Safety Review

A38 Markeaton Roundabout Improvements and Road Safety Audit

MAL/A38MOA-Rev0

03 March 2020

Drawing Title  
FIGURE 2.6  
MARKEATON JUNCTION  
GENERAL ARRANGEMENT

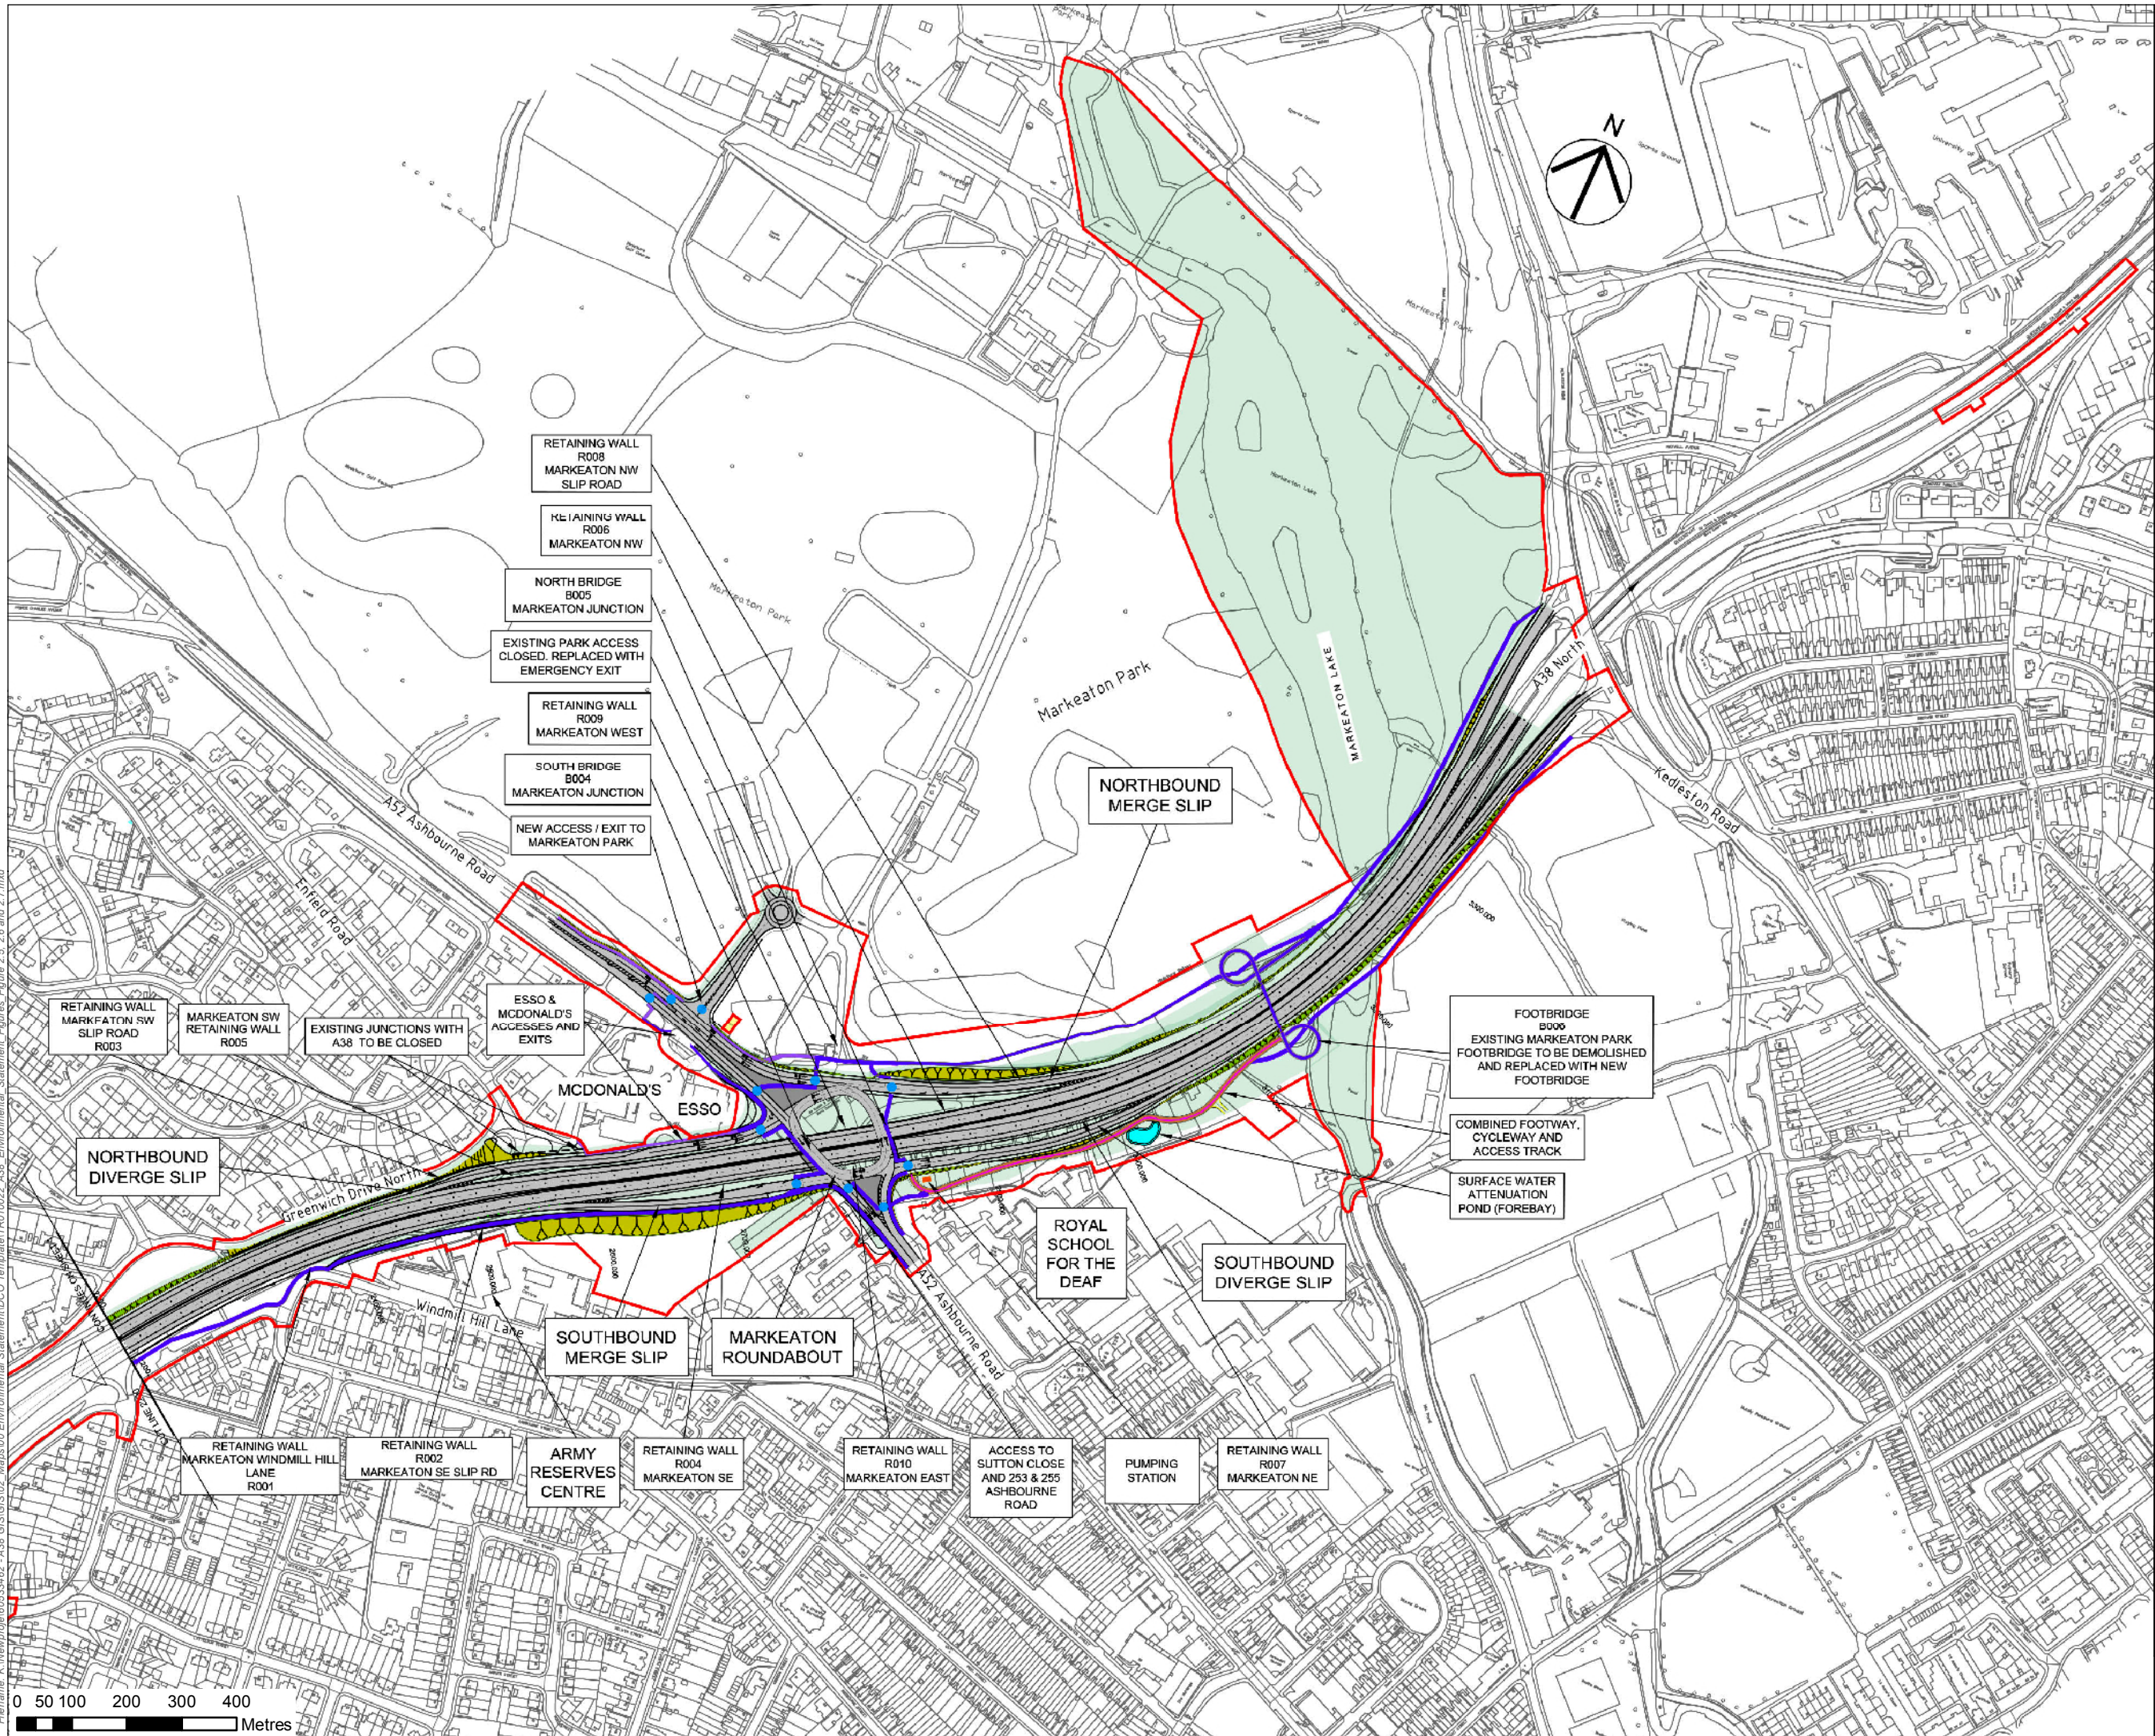
- 2.1.2 To facilitate these increased turning movements a new signalised junction will be constructed close to the existing Esso/McDonalds access onto the A52 Ashbourne Road. As part of these works the access into Markeaton Park will be incorporated into this junction. Examination of the preliminary layout indicates that the left turn into the site is a radius of 3.5m.

- 2.1.3 The issue of the left turn has been considered within the RSA problem 4.3.5. However, it has not considered the full implications of this extremely tight radii and its effect on the access arrangements for Heavy Commercial Vehicle (HCV) entering the site from A52 Ashbourne Road.

- 2.1.4 An articulated HCV will have considerable difficulty in turning left from the A52 into the site. Details of tracking have been considered but the reality may not be quite so easy to achieve.

- Any driver error will result in over running of the footway increasing the risk of NMU/vehicle collisions.
- Vehicles over running the footway will both damage the footway and may strike traffic signal equipment or other street furniture located close to the entrance.

- It is likely that HCVs will use the offside A52 northbound lane to turn left into the site, drivers travelling northbound would not expect this manoeuvre and as such could increase the risk of side swipe type collisions.

- HCVs making very tight turns will scrub away the surface course causing increased damage to the surface material reducing the polished stone value and increasing the risk of loss of control type collisions.

- The radius of the turn is much sharper than drivers would expect and could enter the left turn into the site carrying too much speed resulting in an increased risk of heavy braking resulting in skidding and loss of control type collisions.

- The location of the right turn into McDonalds is very close to the traffic signal junction and could lead to vehicles queuing out onto the A52 resulting in shunt type collisions.

- There is very little distance and therefore time for drivers to understand and react to the new road layout and as discussed above the very close proximity of the right turn into the McDonalds car park could be a serious safety risk. The A38 is a popular route and as such the A38 carries a significant number of drivers who do not know the area well and as such confusing road layouts can increase the risk of collisions. A lack of clear road markings and signing could result in both shunt and failure to give way type collisions.

- The right turn does not meet the current standards set out in CD123.

- 2.1.8 Details of the traffic modelling of the new A52 Ashbourne Road/McDonalds/Esso traffic signalised junction is unavailable and as such there is no understanding of how the improvements will impact on the Markeaton junction. There is concern that the Esso/McDonalds arm will only run for a limited green time every cycle. The McDonalds site is one of the busiest in the country with up to 3000 unique visits a day and the Esso garage 1350 a total of 4350 two-way trips. It is expected that upwards of 2800 vehicles will use the A52 junction to exit the site (allowing 33% to use the A38 exit). These can be particularly high in the morning and more specifically the evening peak period where the peak trips to the restaurant will coincide with the peak period on the A52.

- 2.1.9 It is unclear how the signals will be configured should only a minimum green of seven seconds be allocated to the exit from the site twice a cycle then there is an increased risk of long queues into the site. This will affect the ability of vehicles to both enter and exit the site, especially the right turn into McDonalds car park which could easily become blocked.

- 2.1.11 There is concern that there will be an uncontrolled crossing of the site access details of the layout of this crossing are not provided. The layout of this could affect the position of the stop lines resulting in an increased risk that the junction could become congested.

- 2.1.13 Details of the proposed pedestrian facilities at the junction have been only partly considered as part of the RSA Problem 4.3.7. It does not consider NMU movements across the A52 to and from Markeaton Park. The park is well used with established trips between the park and the Esso/McDonalds site. No details have been provided on how pedestrian movements will be accommodated across the A52. A lack of suitable NMU facilities can increase the risk of NMU/vehicle collisions.

2.1.7 Undertake detailed traffic modelling of the junction and ensure that realistic tracking of left turn HCV's into the site are undertaken. Implement additional signing works for the right turn into the McDonalds.

- 2.1.12 Undertake detailed traffic modelling of the junction and if queues block the entrance into McDonalds consider the use of "Keep Clear" markings and perhaps ensure that detection used on the exit from the site is positioned appropriately ensuring that queues are kept to a minimum.

- 2.1.14 Undertake detailed observations including NMU counts (Saturdays and Sundays) to determine the NMU demand at the proposed junction and if necessary, consider including signalised/un-signalised facilities at the junction (covering the A52 and site access). If traffic signal control of the NMUs is required, then detailed modelling of the changes will be required. This could have a material impact on the capacity of the junction.
